Application Ref:	3/2026/0629			 Ribble Valley Borough Council www.ribblevalley.gov.uk
Date Inspected:	26/8/26 & 21/9/26	Site Notice:	26/8/26	
Officer:	BT			
DELEGATED ITEM FILE REPORT:				
				REFUSAL

Development Description:	Regularisation of existing as-built clear glazing to the dormer and roof windows.
Site Address/Location:	29 Chatburn Park Drive, Clitheroe, BB7 2AY.

1
EXISTING EAST
1 : 50

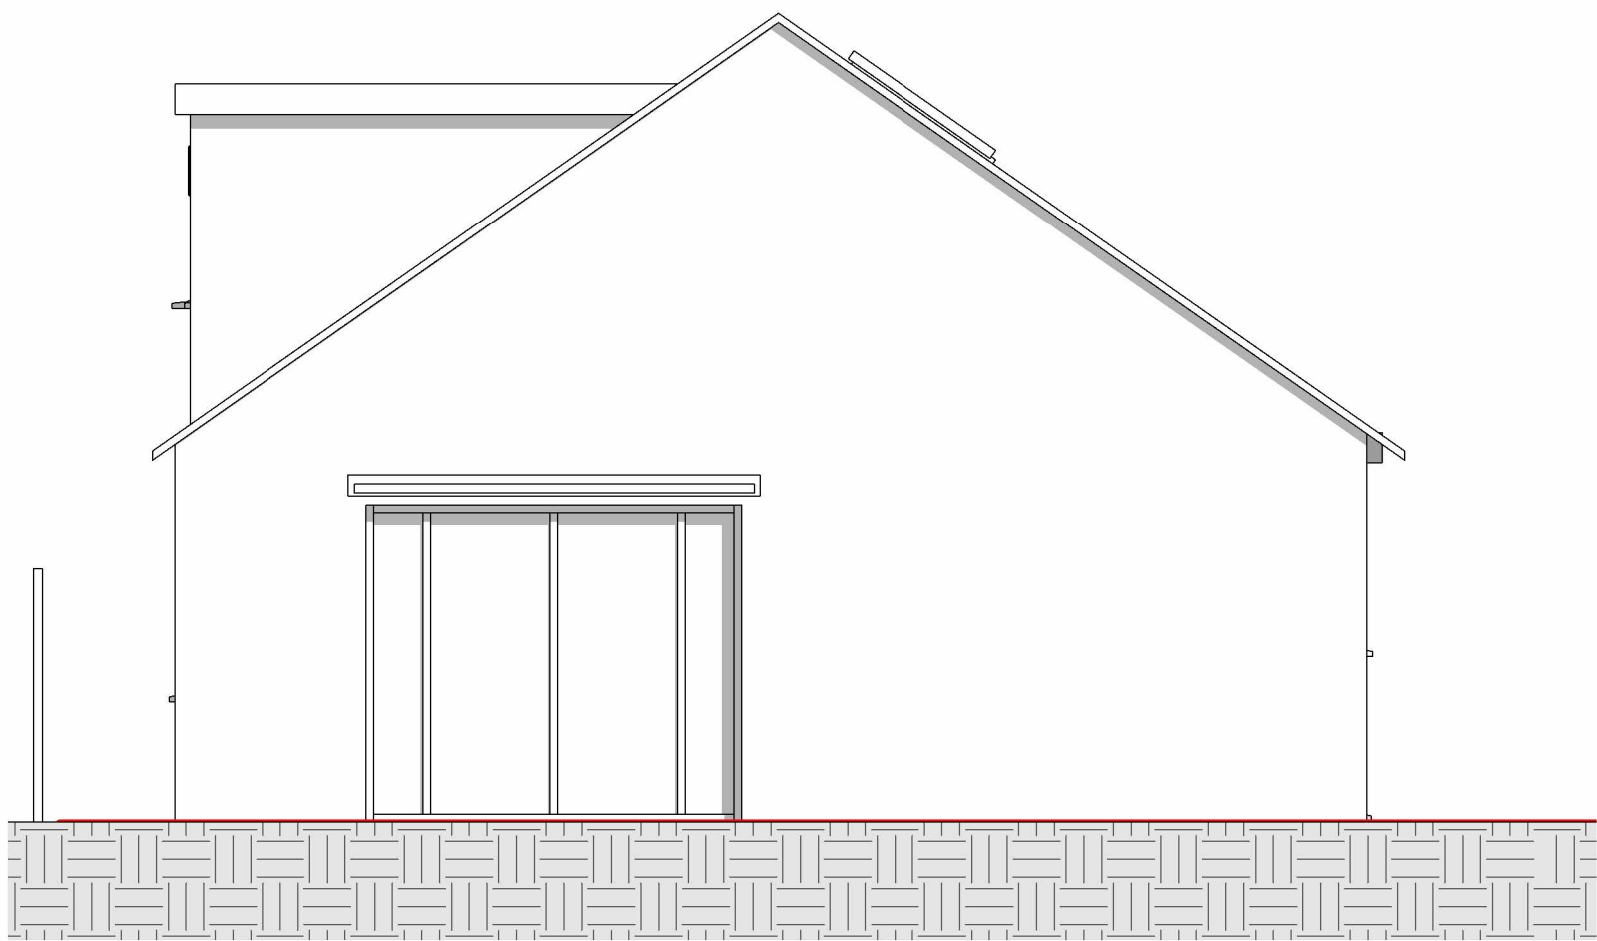
In this instance, officer site visit photo analysis from the interior of the application property and exterior of the rear garden area serving No. 31 Chatburn Park Drive shows that the unauthorised windows serving the landing and guest bedroom areas of the property's dormer extension provide unrestricted, elevated sideways views into the rear garden area of No. 31 Chatburn Park Drive and also towards the windows within the rear elevation of No. 31 Chatburn Park Drive. In addition, photographic analysis shows that the window serving the main bedroom area of the property's dormer extension provides unrestricted views towards the first floor windows within the side elevation of No. 31 Chatburn Park Drive. It is noted that the applicant has installed shutter blinds to each of the three windows within the dormer extension in an attempt to mitigate losses of privacy to the adjacent neighbouring property however photographic analysis shows the aforementioned occurrences of overlooking as still being prevalent with the blinds in place. As such, it is considered that retention of the unauthorised windows would result in an unacceptable loss of privacy to the neighbouring residents of No. 31 Chatburn Park Drive.

In addition, whilst officer site visit photo analysis from the interior of the application property does not show clear lines of sight towards the first floor window opening within South-western gable end of No. 27 Chatburn Park Road or its rear garden area, it is considered that the unauthorised rooflights could provide opportunities for overlooking towards the aforementioned bedroom window and rear garden area, particularly from the perspective of taller occupants. Furthermore, officer site visit photo analysis from the interior of the aforementioned first floor bedroom window within No. 27 Chatburn Park Drive show clear intervisibility between the bedroom window opening and unauthorised rooflights with the interior of the application property's landing and shower room areas also being partly visible which in turn creates the perception of being overlooked. As such, it is considered that retention of the unauthorised rooflights would result in an unacceptable loss of privacy to the neighbouring residents of No. 27 Chatburn Park Drive.

Taking account of the above, it is considered that retention of the unauthorised windows and rooflights, by virtue of their height, orientation and proximity to the neighbouring properties of No. 27 Chatburn Park Drive and No. 31 Chatburn Park Drive would be unduly harmful to the amenity of the occupants of these properties due to the resultant loss of privacy that would occur. The proposed development would therefore fail to satisfy the requirements of Policy DMG1.

01:	Retention of the unauthorised windows and rooflights, by virtue of their height, orientation and proximity to the neighbouring properties of No. 27 Chatburn Park Drive and No. 31 Chatburn Park Drive would be unduly harmful to the amenity of the occupants of these properties due to the resultant loss of privacy that would occur. The proposed development would therefore fail to satisfy the requirements of Policy DMG1.
------------	---
